From:  **Sent:** 30 September 2014 10:14
To: 'Phil Brown'
Subject: RE: 37 King Street, Arundel - AB/97/14/L and AB/96/14/HH

From: Phil Brown 
Sent: 26 September 2014
To: Damian Sullivan
Subject: 37 King Street, Arundel - AB/97/14/L and AB/96/14/HH

DRAWING TITLE
PROPOSED FLOOR PLANS, ROOF PLAN,
SECTION AND ELEVATIONS

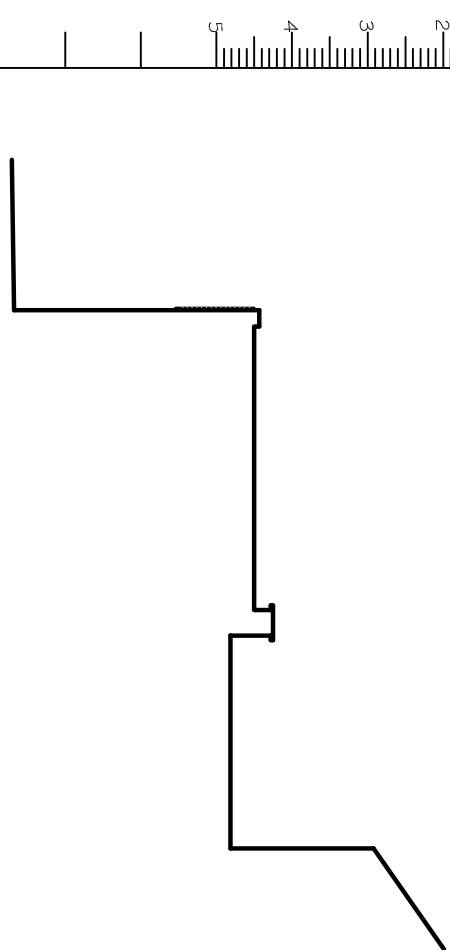
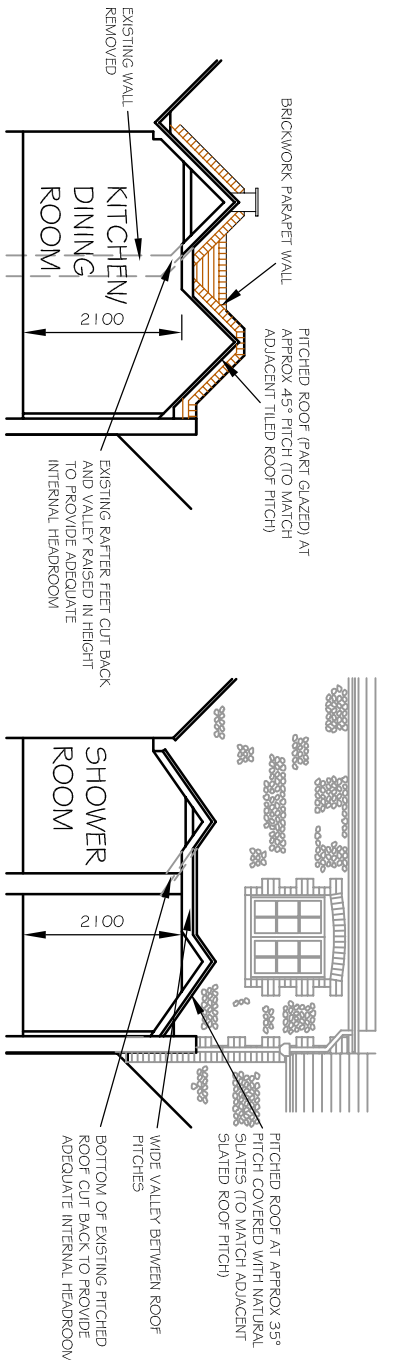
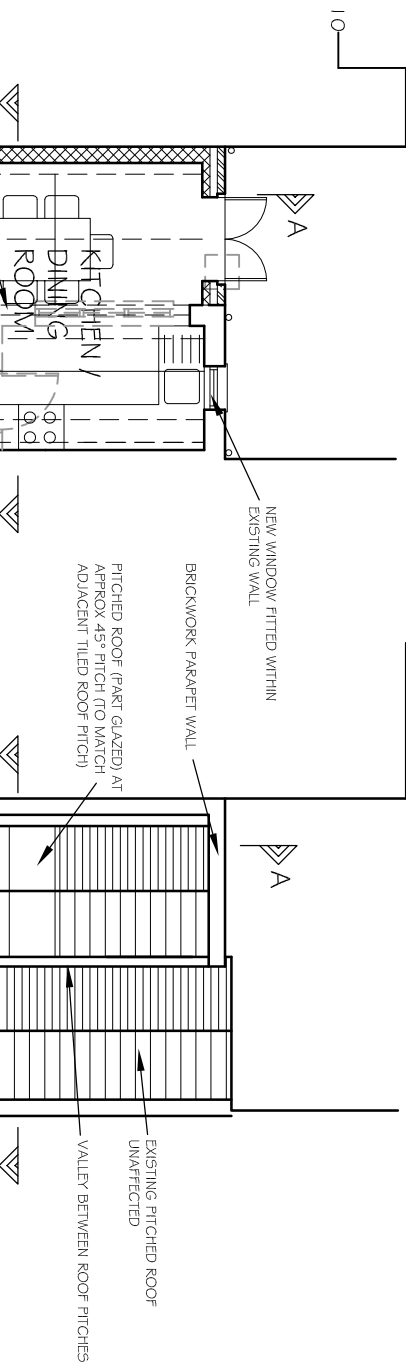
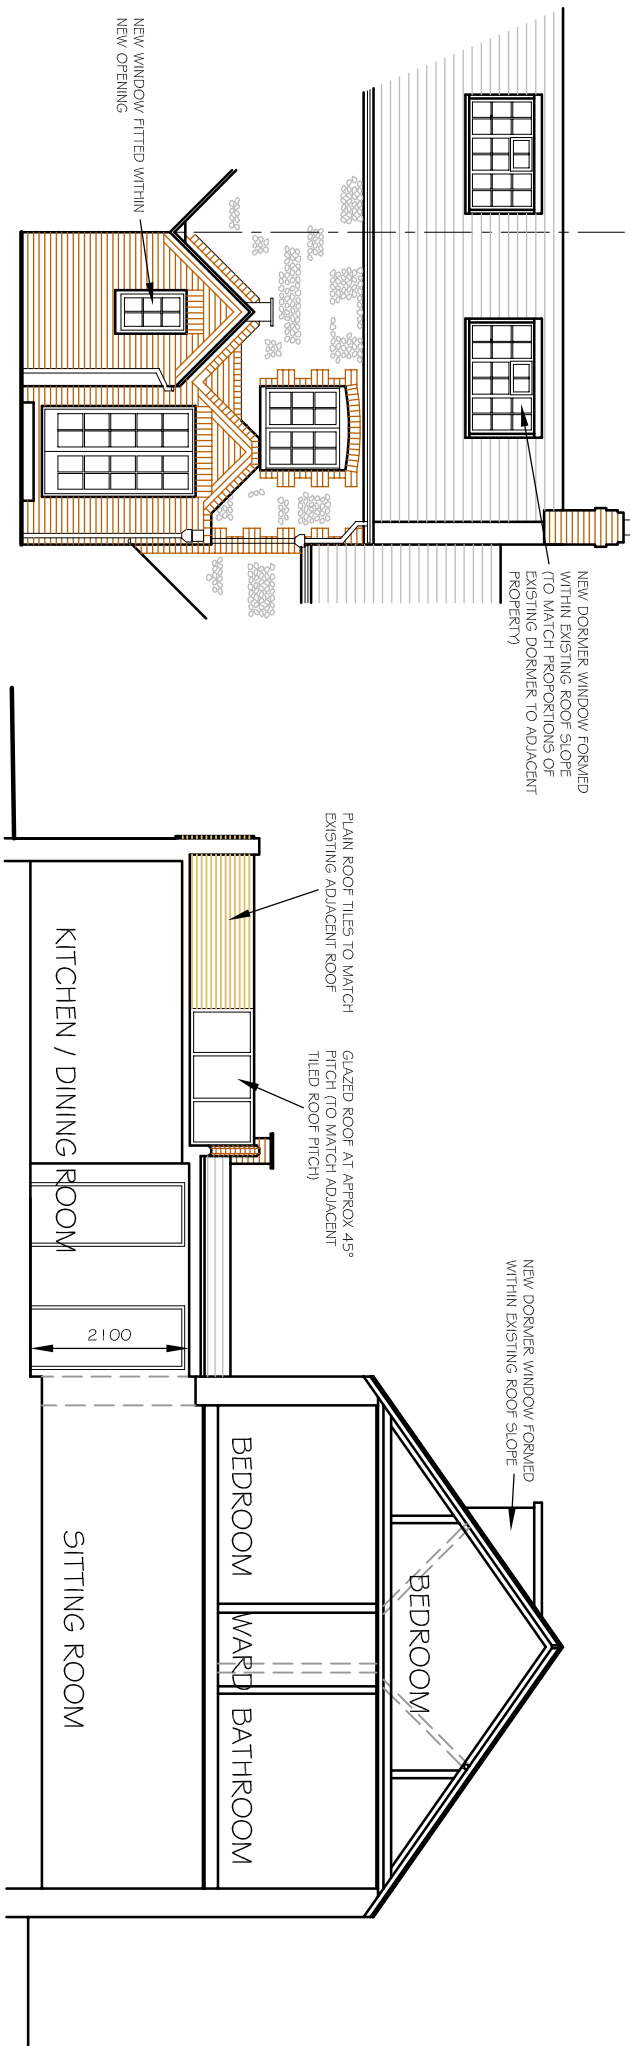
- The current staircase is of a modern design and is not of historic interest. There is clear evidence – through beams and downstands within the ground floor ceiling – that the position of the current staircase may not be original. We accept that historic layouts should be maintained wherever possible, but are not convinced that the staircase in the current position is of historic significance.

- Following pre-application discussions, we have already amended various aspects of the design of the proposed rear extension. The roof design would complement the appearance of the property, and would enable the extension to clearly read as new work, thus helping to define the evolution of the property. The new roofs and detailing would broadly mirror the existing roofs to the rear outshoot whilst also introducing a contemporary element of glazing within the roof, which would be fully complementary. An area of flat roof would join the new roofs to the existing – whilst ensuring adequate internal headroom – and the ridge height of the new roofs would be no higher than the existing roofs. Accordingly, we believe this approach to be a highly suitable design solution, and do not accept Ian Wightman's statement that the new roof would be 'overly complex'.

- We would be prepared to amend the design of the proposed dormer window if required, and please let us know if you would like us to submit some amended drawings for this element.

We are unfortunately not in a position to accept revised plans for any alterations to the rear extension due to the need to readvertise and a strict adherence to determining the application in time. You can, should you wish to, withdraw this application and submit drawings for Dr. Whiteman to informally consider before any resubmission. Alternatively, you can allow the planning application to run its course and await its determination but owing to Dr. Wightman's advice it does not seem favourable, but there is always the right of appeal if you do not agree with his comments.
